From:
Sent: 29 November 2018 11:59
To: DCAdmin
Cc:
Subject: 2018/92647 Former Kirklees College New North Road, Huddersfield
Attachments: hdm comments.docx

Highway Development Management's (HDM) comments for the above application as follows:

Planning application for the mixed use development of former Kirklees college site to form retail/office units and 239 residential units associated access and car parking provision.

02 Accessible Pedestrian Routes into Buildings 2 + 3

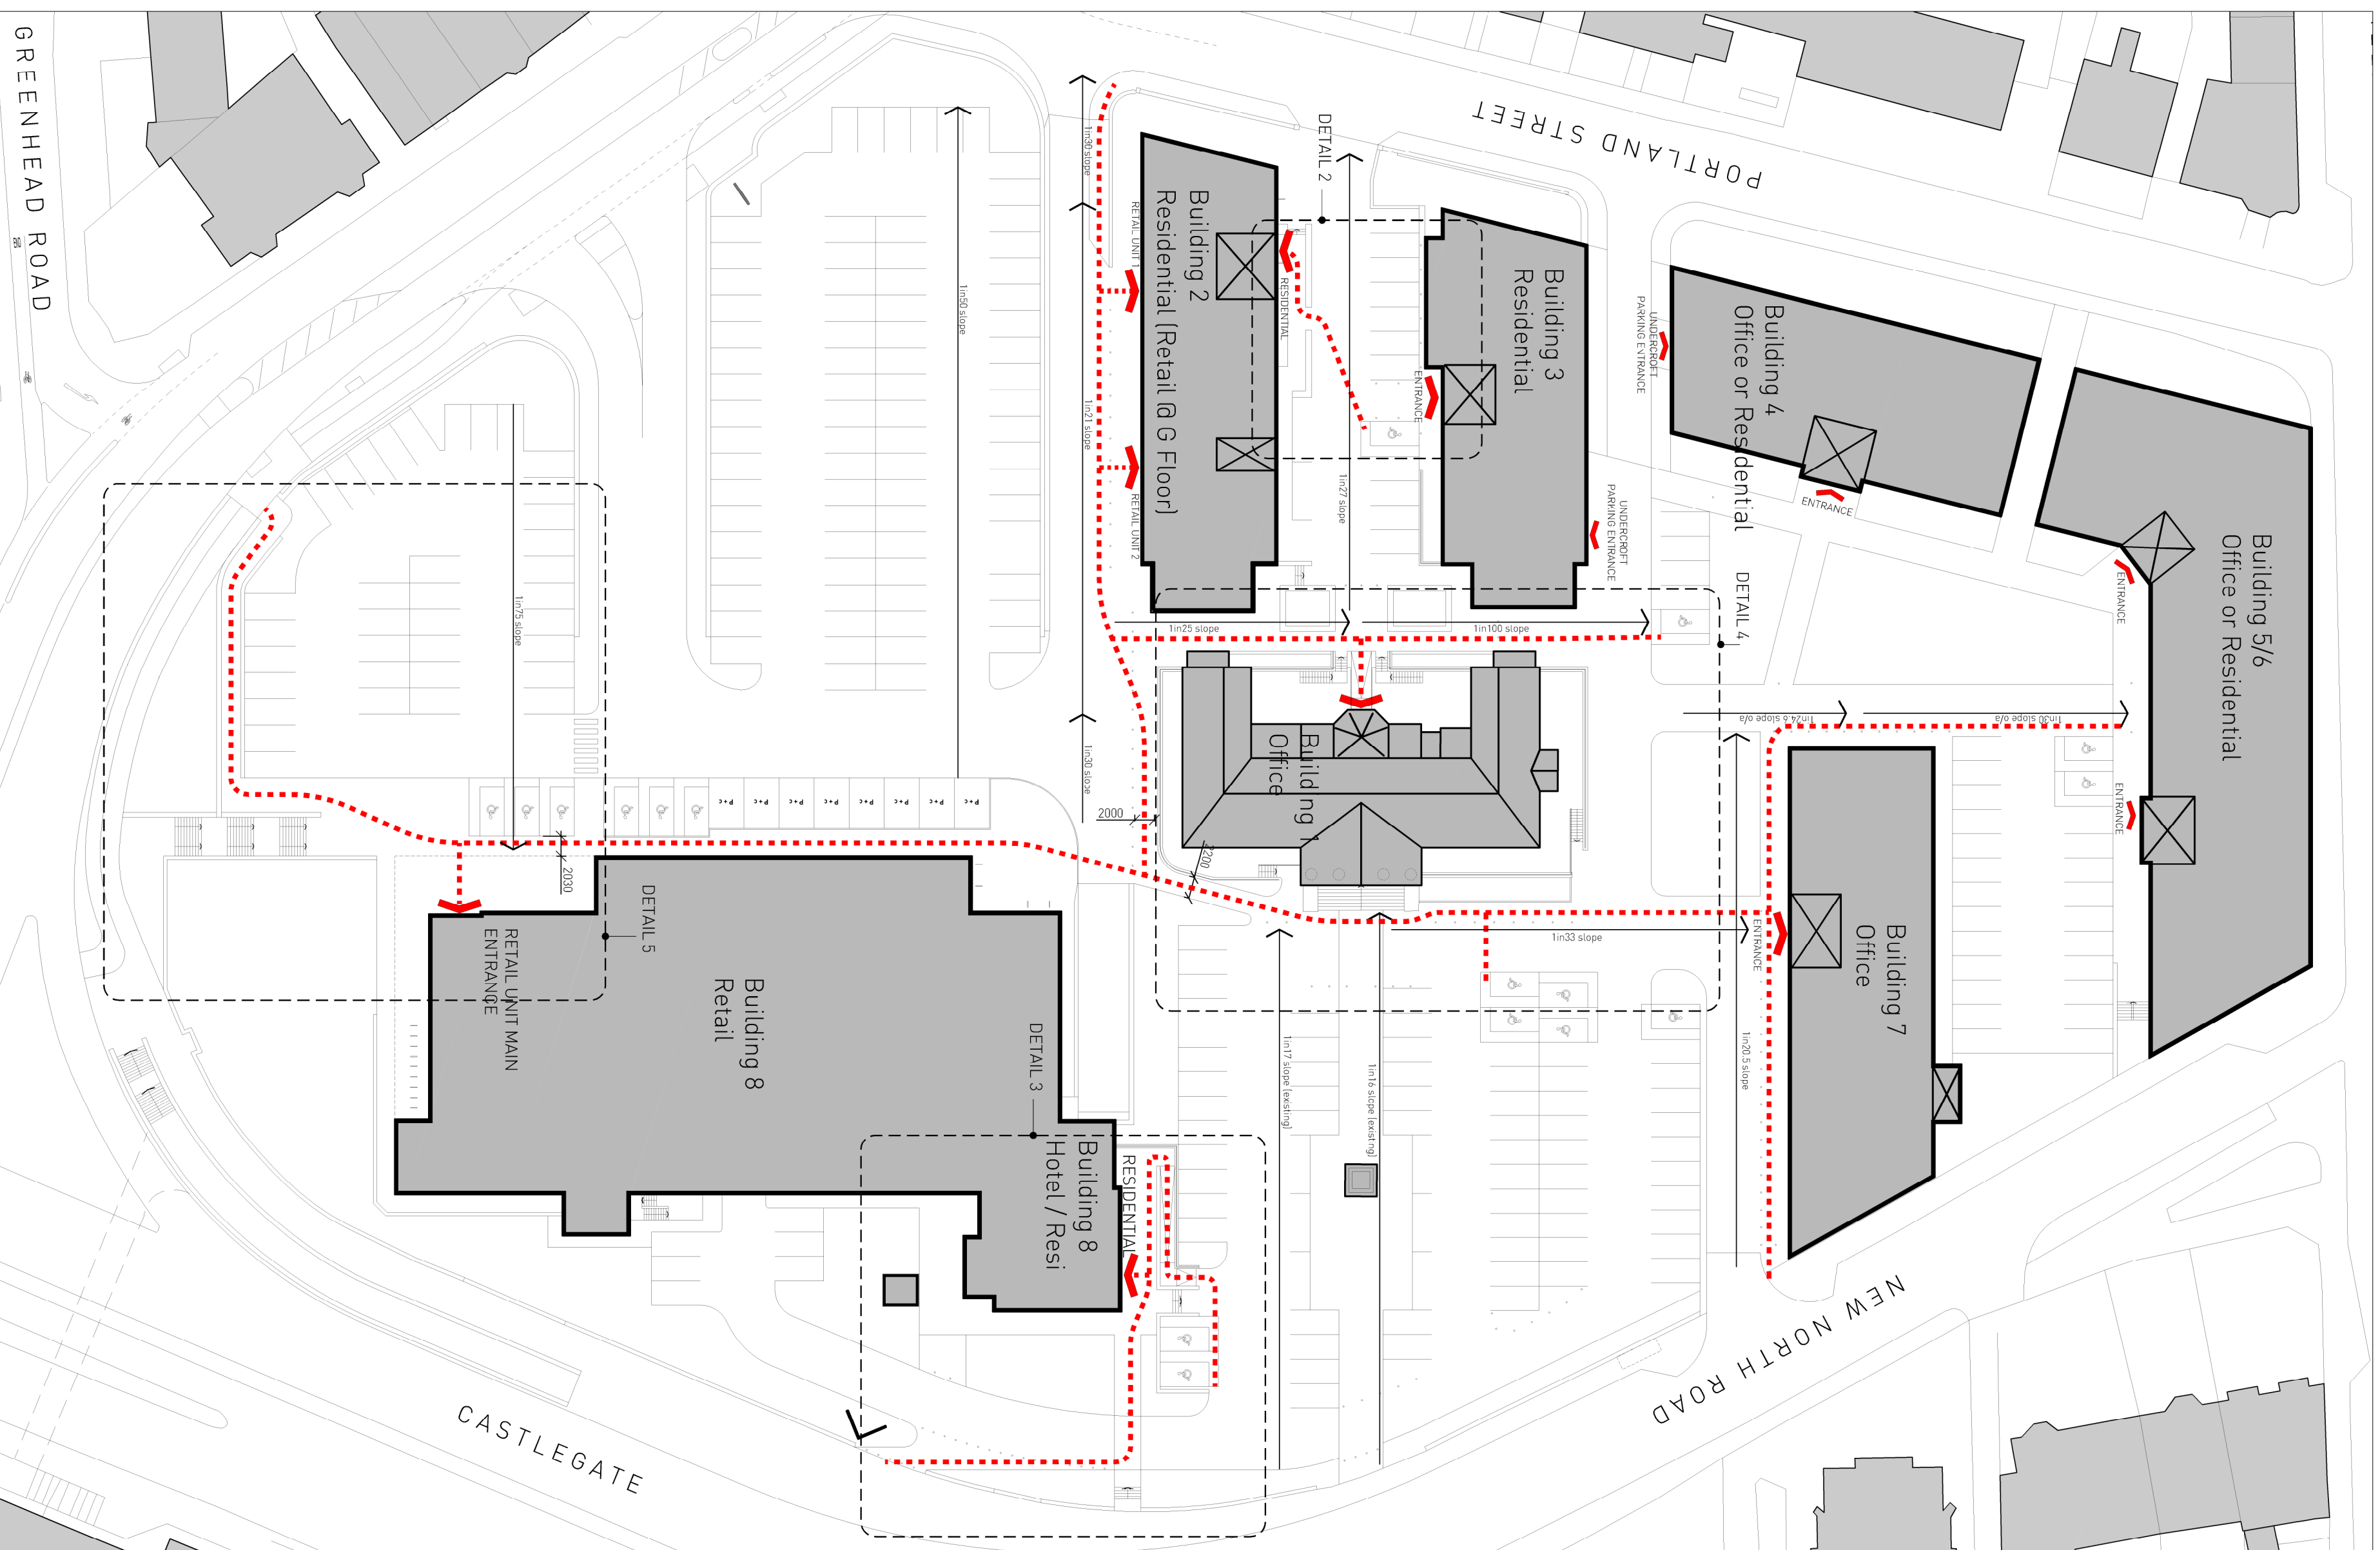
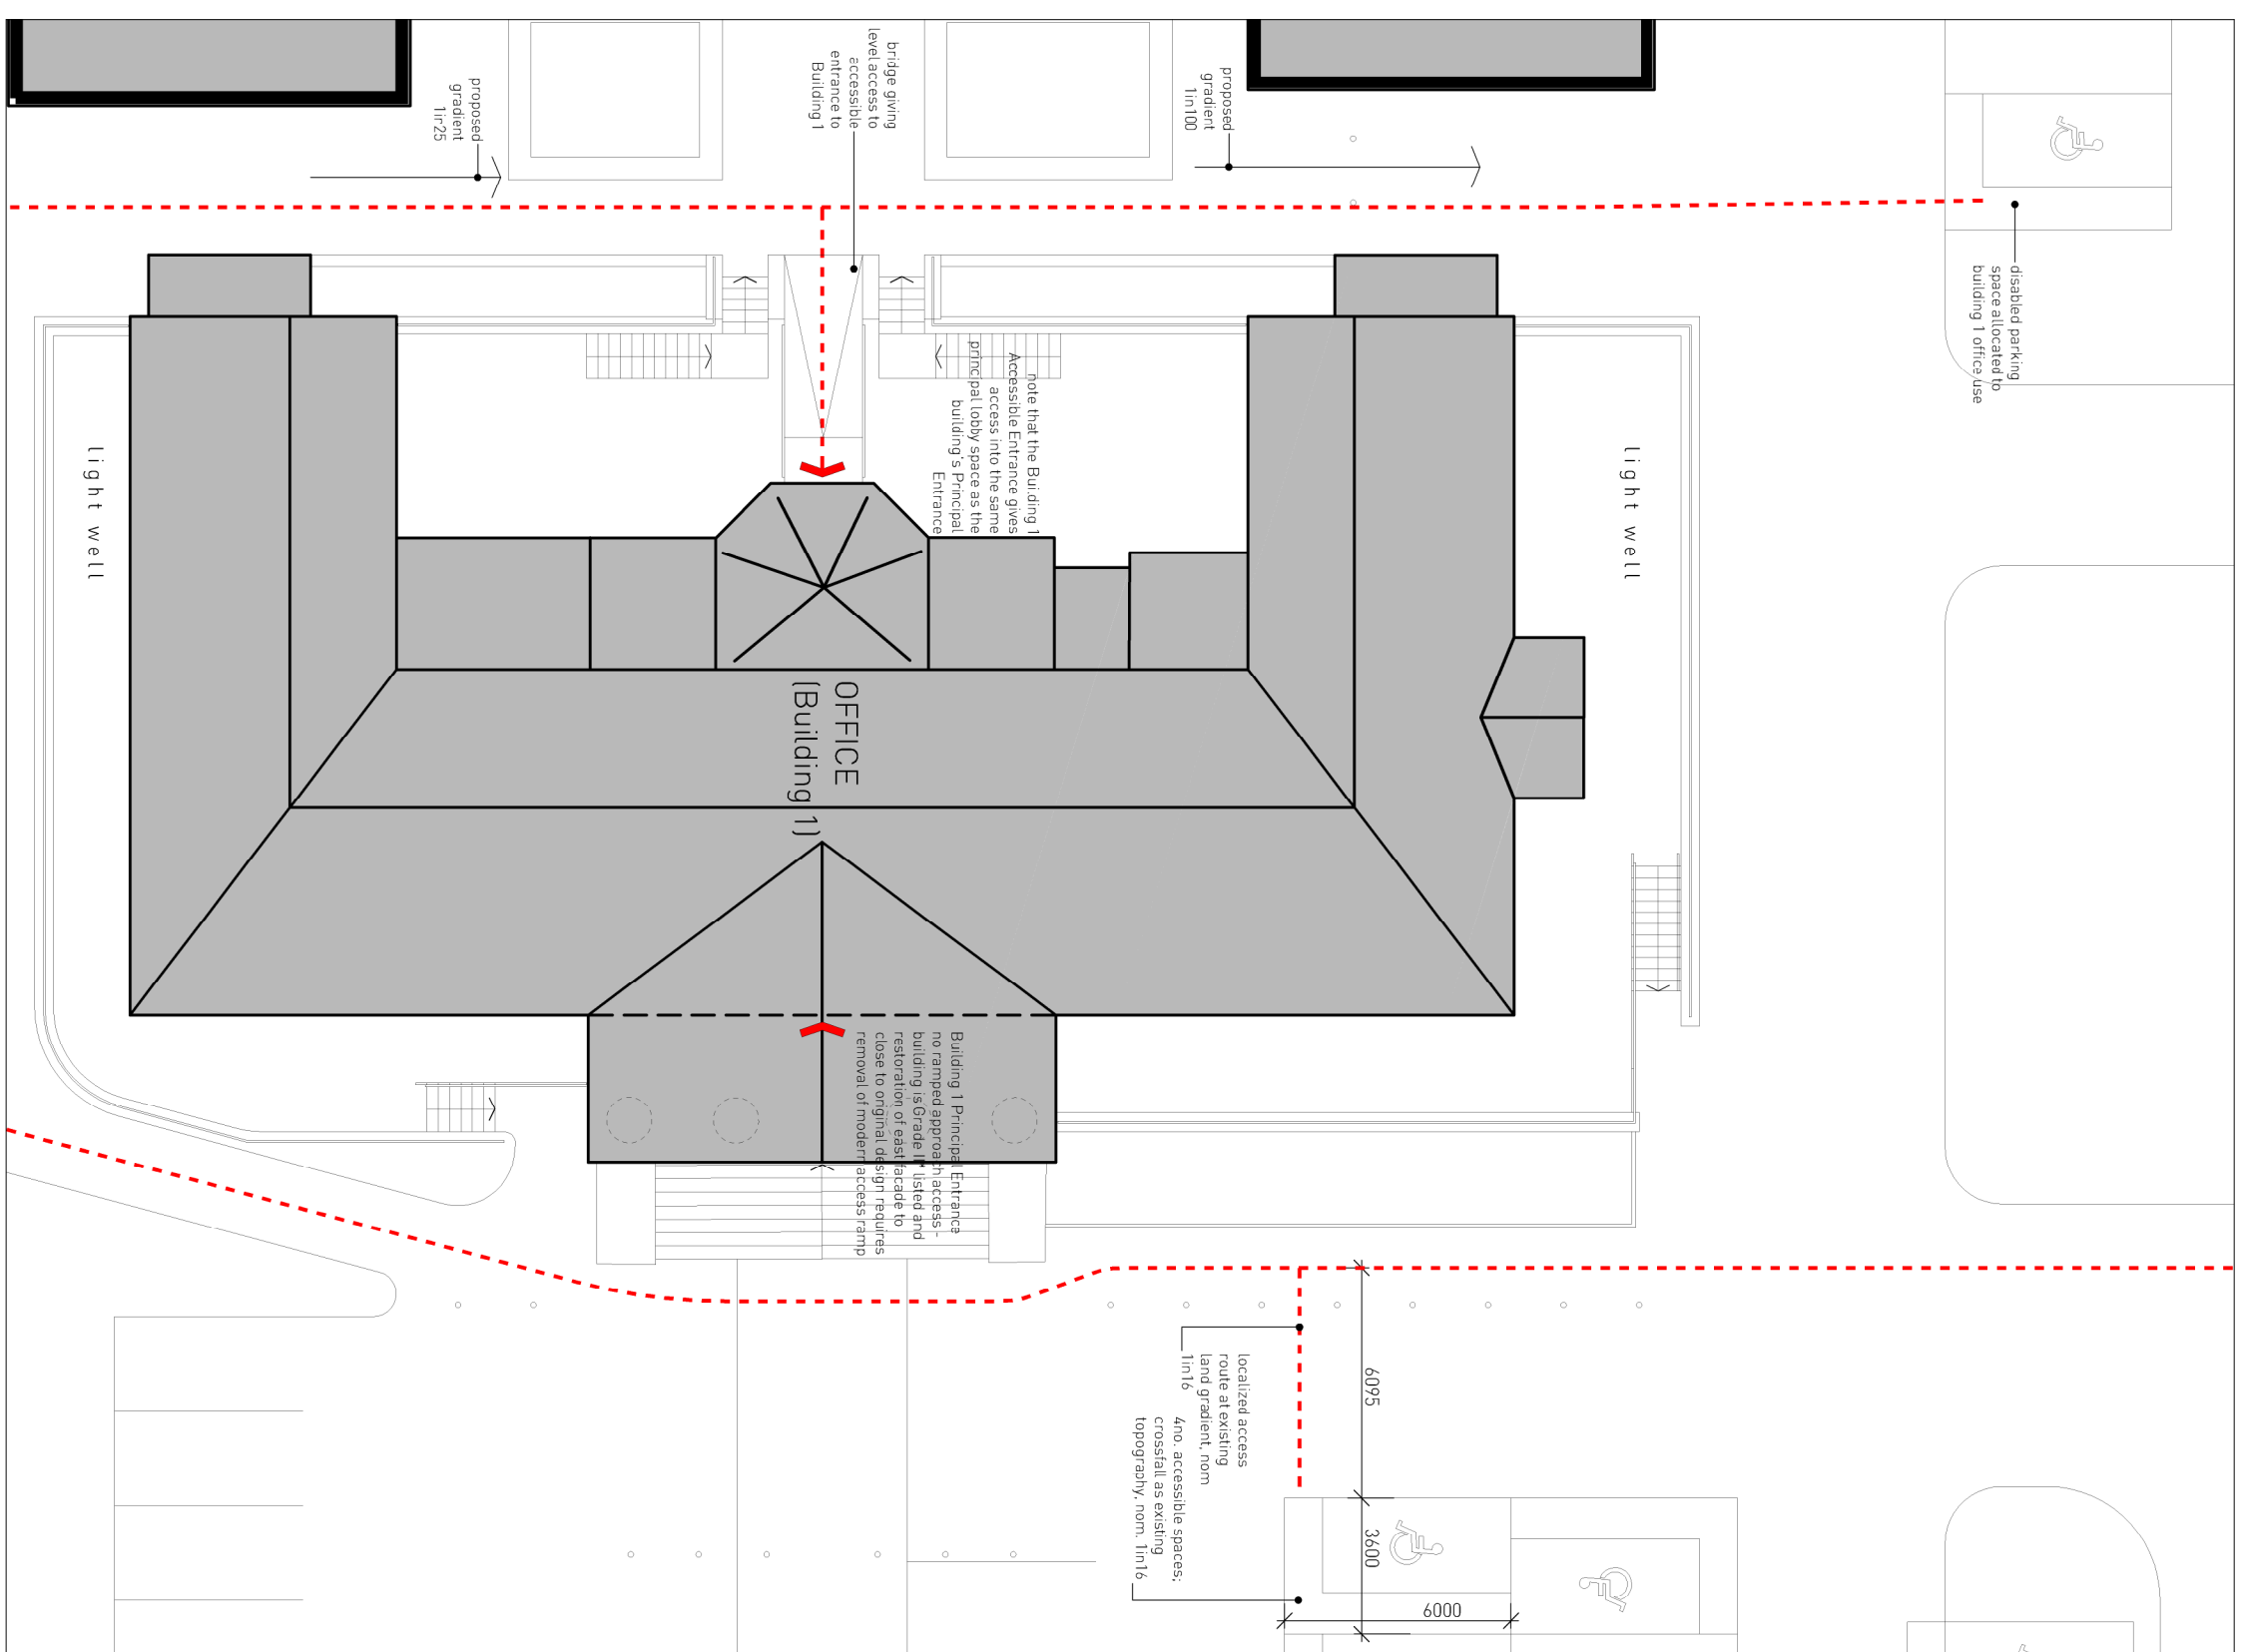
- Improvements to the existing subway are required to improve pedestrian safety.
- Vehicle Priority in and out of all site entrances needs clarifying, some access widths appear too narrow to accommodate two way traffic.
- Dependent on the access arrangements, appropriate visibility splays should be demonstrated.
- The width of the existing footway along the site boundaries should be improved to aid pedestrian safety/landscaping.
- A stage 1 safety audit and designer's response to cover all aspects of works should be submitted.
- Pedestrian routes within the site should be of 2.0m min width.
- Refuse collection arrangements need clarification.
